I live in the rural community of Sturton by Stow, currently being threatened by solar farms, which in total amount to 10,000 acres (16.25 square miles of glass panels 4.5 metres high), which if approved will surround us completely, ruining the agricultural, picturesque, and historical landscape of the Trent Plain.

Although the developer claims West Burton Solar to have a 'potential' output of 600MW, the average annual load factor at northern latitudes is a maximum of 11% and will therefore deliver a maximum average of only 60MW throughout the year. Solar panels do not produce power during the night or during cold winter months when power is most needed.

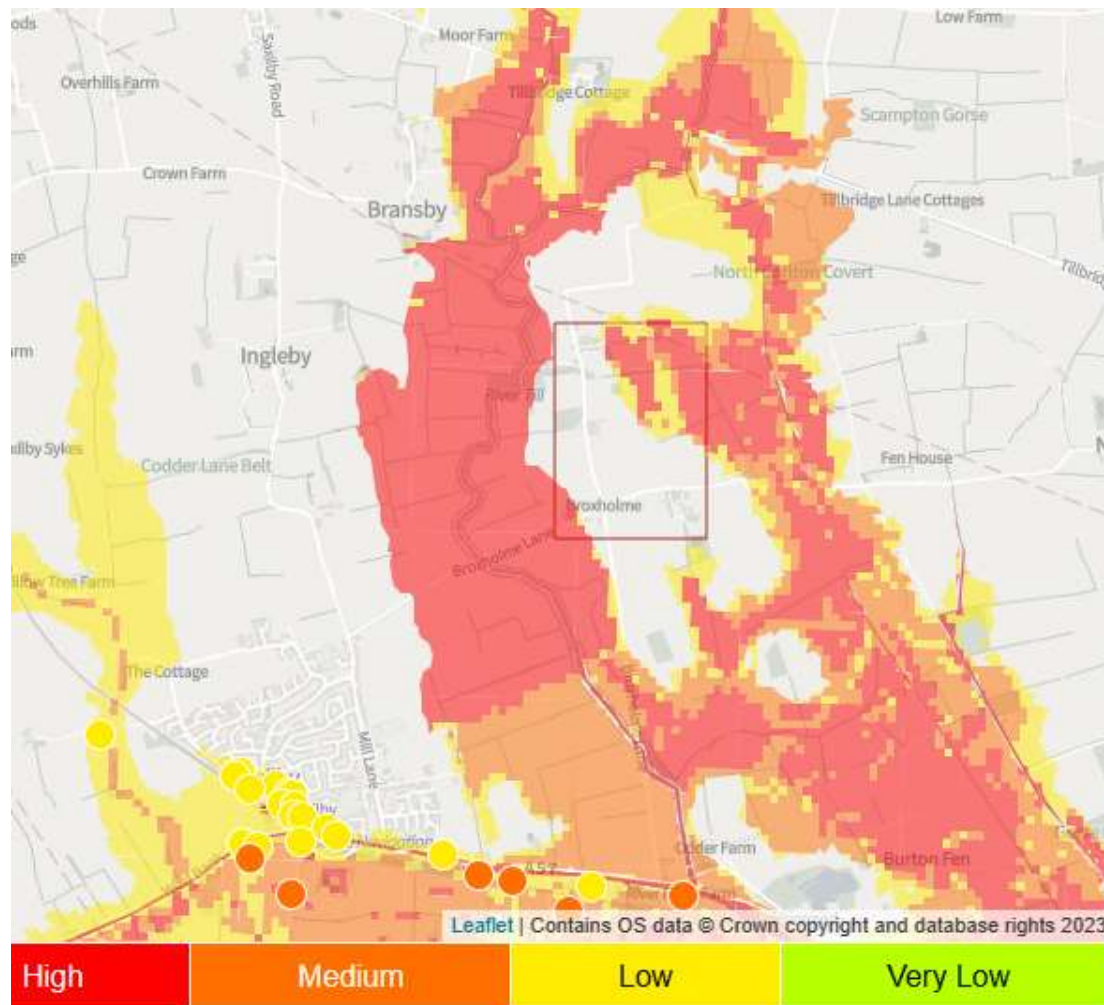
The areas within and around West Burton 1 and West Burton 2 were completely inundated in November 2019 and on 21 October 2023, as were thousands of acres of adjacent productive farmland extending from Odder to Normanby along the banks of the river Till.

Under storm conditions, when the water level in the river Witham is high, the Environment Agency and Upper Witham Drainage Board routinely turn off the transfer pumps on the River Till to prevent flooding around the Brayford Pool in centre of Lincoln, causing the River Till to overflow its flood banks, inundating farmland and the access roads to the villages of Stow, Sturton by Stow, Bransby and Broxholm.

West Burton Power Station Plan

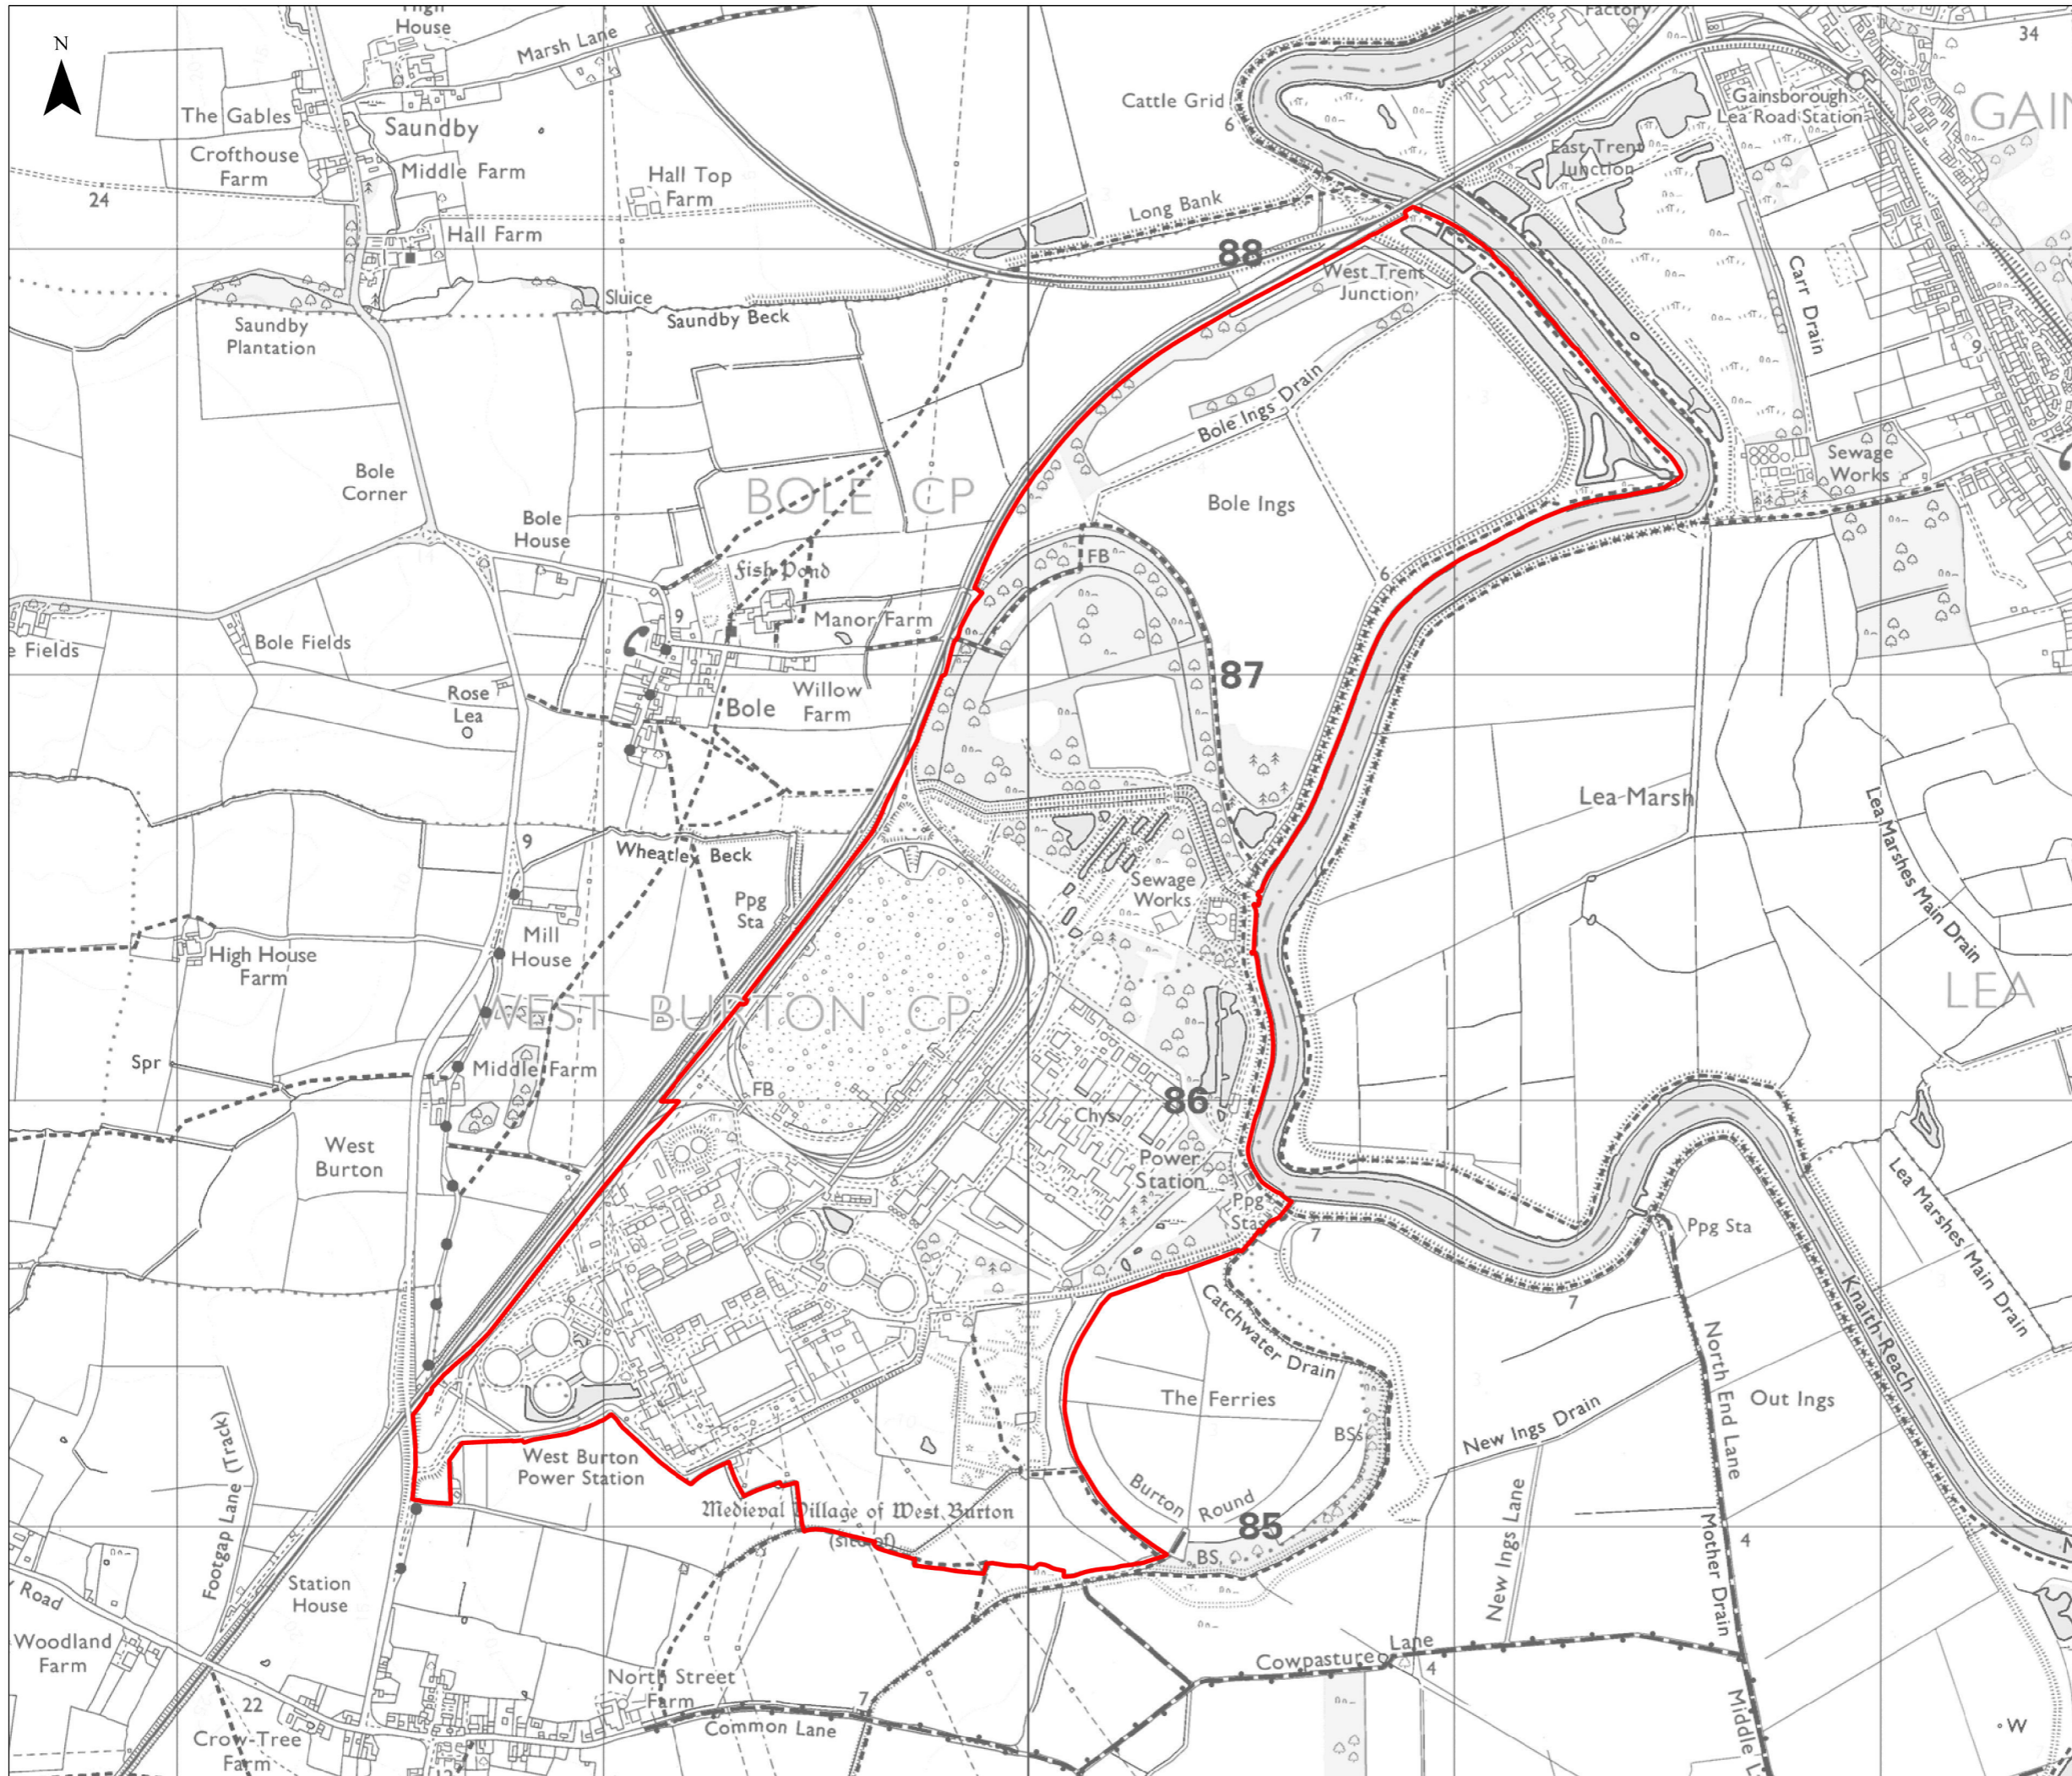
This brings into question the justification for not siting the BESS at West Burton Power Station and consideration by the Planning Inspectorate under a separate planning application from the National Grid as the main user.

West Burton Power Station is sited is well away from populated areas, is supervised, contained, controlled, already has adequate water supplies and good road access for the Nottinghamshire Fire Brigades, which have attended serious fires at this location in the past, when the station was operational.

The 400kv connection to the National Grid currently being considered at West Burton would be far better utilised by receiving the output from several small modular nuclear reactors (SMR's), which would provide a continuous source of zero carbon electricity, not intrude on the landscape, nor take up productive farmland.

West Burton Power Station is uniquely suitable for SMR's by its remote location, cooling water supplies and grid connections and should be considered as part of an integrated national energy infrastructure strategy along with food and agriculture extending into the future.
